7 November 2017

File No: SSD 7974
Our Ref: R/2016/33/A

SSD 7974 – University of Sydney – Health Precinct Stage 1

I refer to your letter dated 9 October 2017 seeking Council's input on the above subject SSD application.

Figure 6.15 Vegetation Management Plan (showing trees to be retained, removed and replaced)
(source: Drawing prepared by Arcadia landscape Architecture (August 2017))

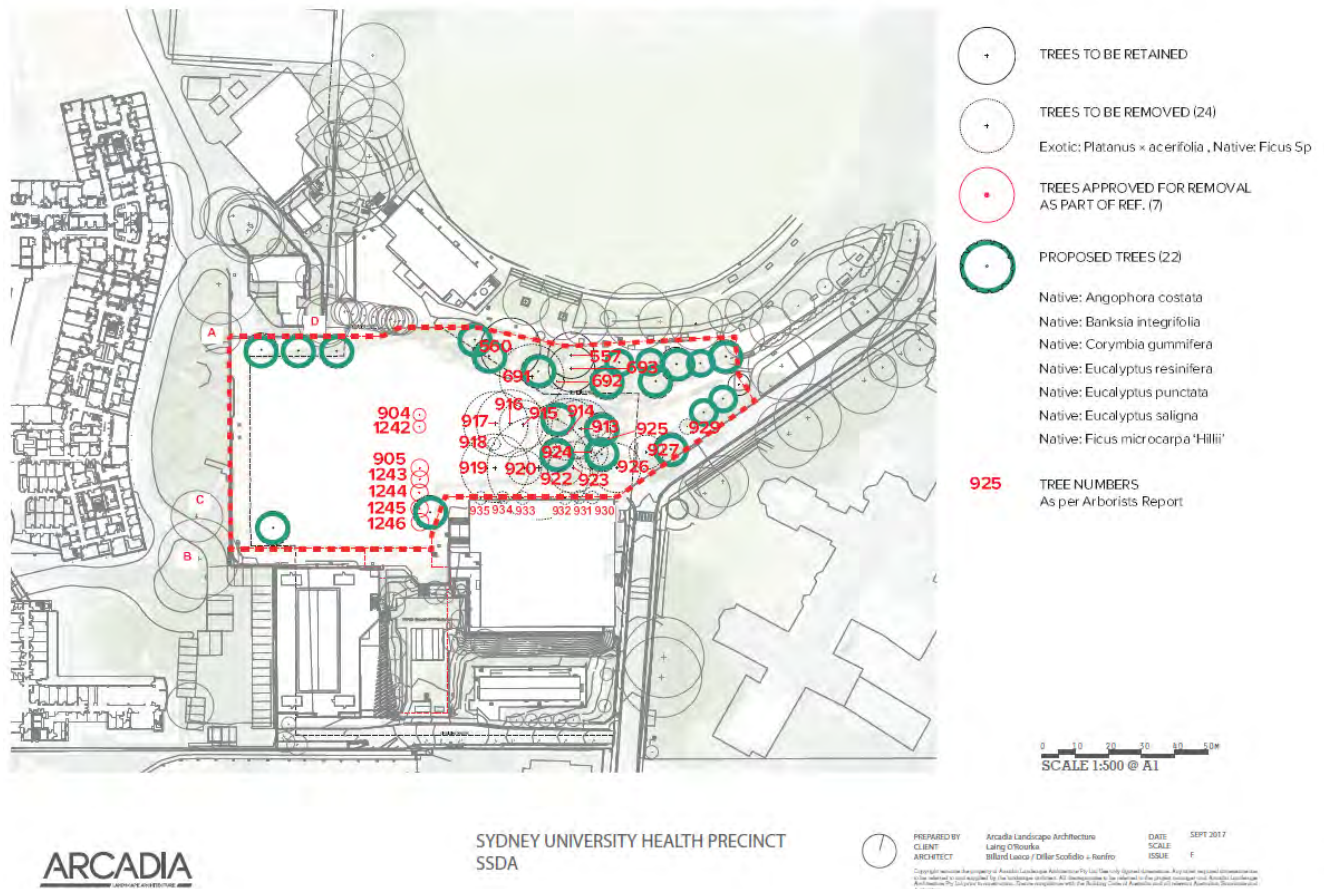
Adequate, viable tree replacement is a critical aspect of this application, particularly given the wholesale loss of existing large mature trees with a moderate retention value. These existing trees make a significant contribution to the overall canopy cover on campus, and also to local habitat linkages. The indicative sections (particularly 'Lower Wakil Sections A & B') illustrate insufficient soil depth and volume to support the large species proposed. Mounding to achieve a minimum depth at the trunk is an unacceptable approach for planting of this scale on podium, and the minimum substrate depth (800-1000mm) must be achieved for the majority of all planters. The planter edge detail should be revised to accommodate this.

The proposal indicates that only three trees are to be retained. In order to ensure these trees remain viable, it is recommended that the proposal adopts all of the recommendations stated within the plans, Arborist's Report and the Arboricultural Impact Assessment, including tree protection specifications.

WT-A1/2 (UPPER BOXES)

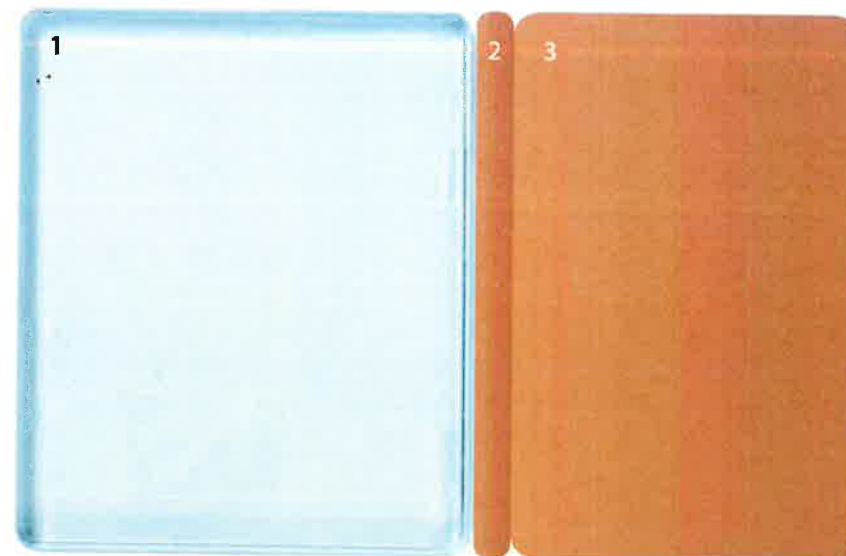
Insufficient detail is provided in relation to the proposed colours, materials and finishes for the development. For example, the 'Exterior Finishes' sheet shows "WT-

A1/2 (Upper Boxes)” with material 3 annotated as “*L shaped folded fins fixed to slab edges*”. This is a design description and fails to clarify the proposed material the fins will be constructed from as well as the actual colour for which approval is sought. This lack of specific detail is typical of most of the materials including the glazing, type of “composite material” and the “horizontal fins” and “external tile panels”. A detailed schedule of materials, colours and finishes should correspond to coloured elevations so it is clear where the details specified are to be located on the building.

00 1.16 LOWER WAKIL PLANTER - TYPICAL SECTION
SCALE 1:50

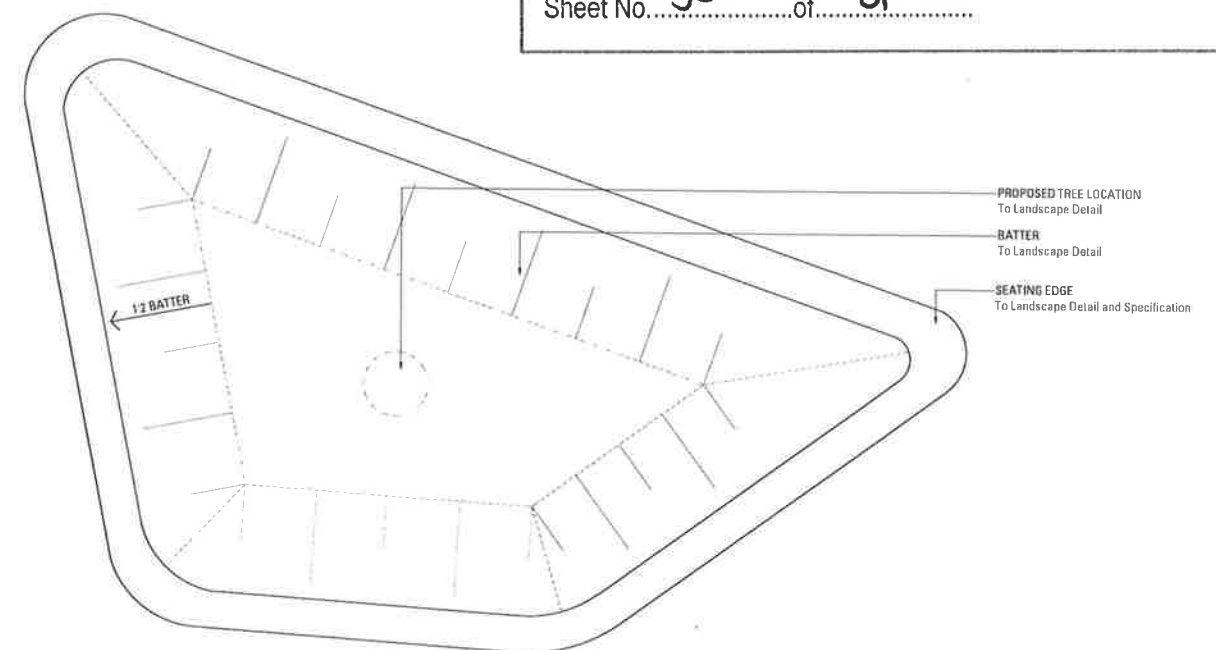
The landscape concept diagrams highlight several areas on both levels that are designed for social interaction. However, the design of the raised planter/seating edges in these spaces is generally linear, and will only support interaction of small groups of 2-3 people. The spaces, in particular the Lower Wakil Garden, appear to have been designed more as a thoroughfare than a social space. It is recommended that the planters be redesigned to incorporate a more detailed, articulated edge that facilitates interaction for groups of people, particularly in the Upper Wakil Garden where space is more generous.
